**DETAIL: UTILITY SERVICE LOCATIONS**  
N.T.S.

RETRAIT AT TIMBERIDGE FILING NO. 3 CONSTRUCTION PLANS UTILITY SERVICE PLAN	DESIGNED BY PRA SCALE	DATE 12-8-2022
CLASSIC CONSULTING	DRAWN BY PRA (H) 1" = 60'	SHEET 6 OF 7
	CHECKED BY (V) 1" = N/A	JOB NO. 1185.30

DESIGNED BY PRA SCALE DATE 12-8-2022  
DRAWN BY ESO (H) 1" = 50' SHEET 5 OF 7  
CHECKED BY (V) 1" = 5' JOB NO. 1185.30

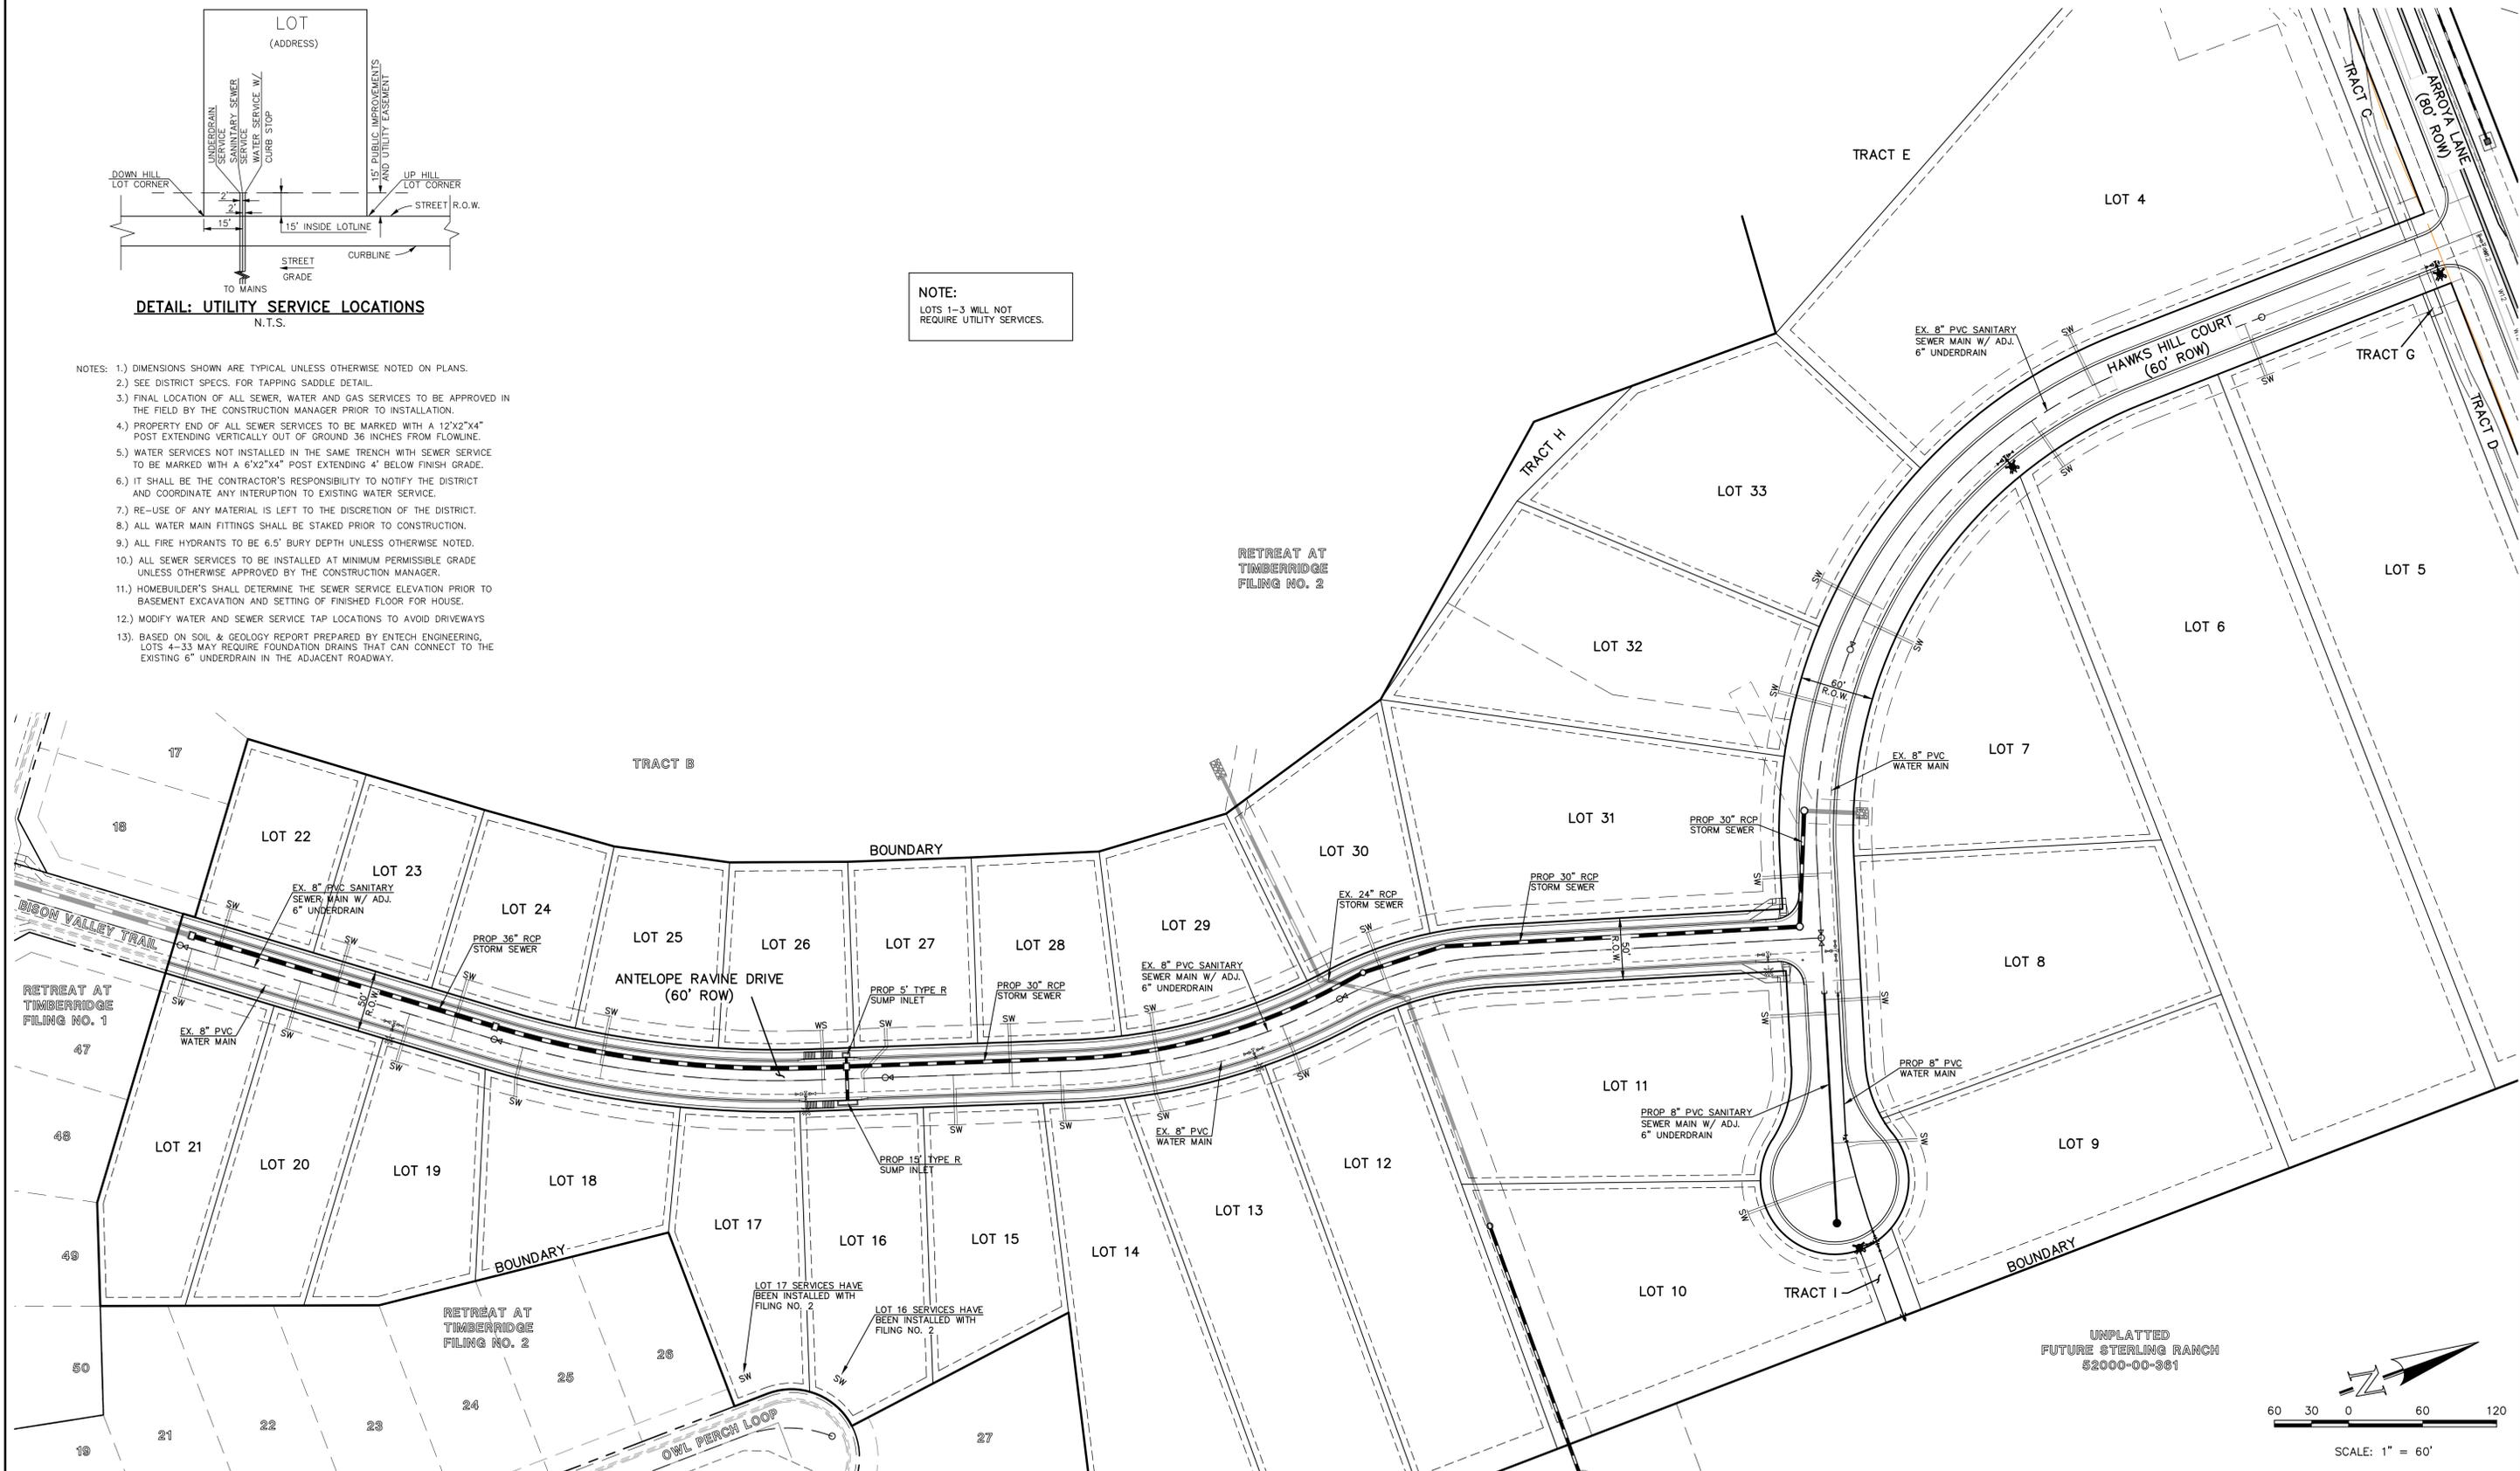
**Unresolved:**  
Note and/or show the underdrain system outfall locations.
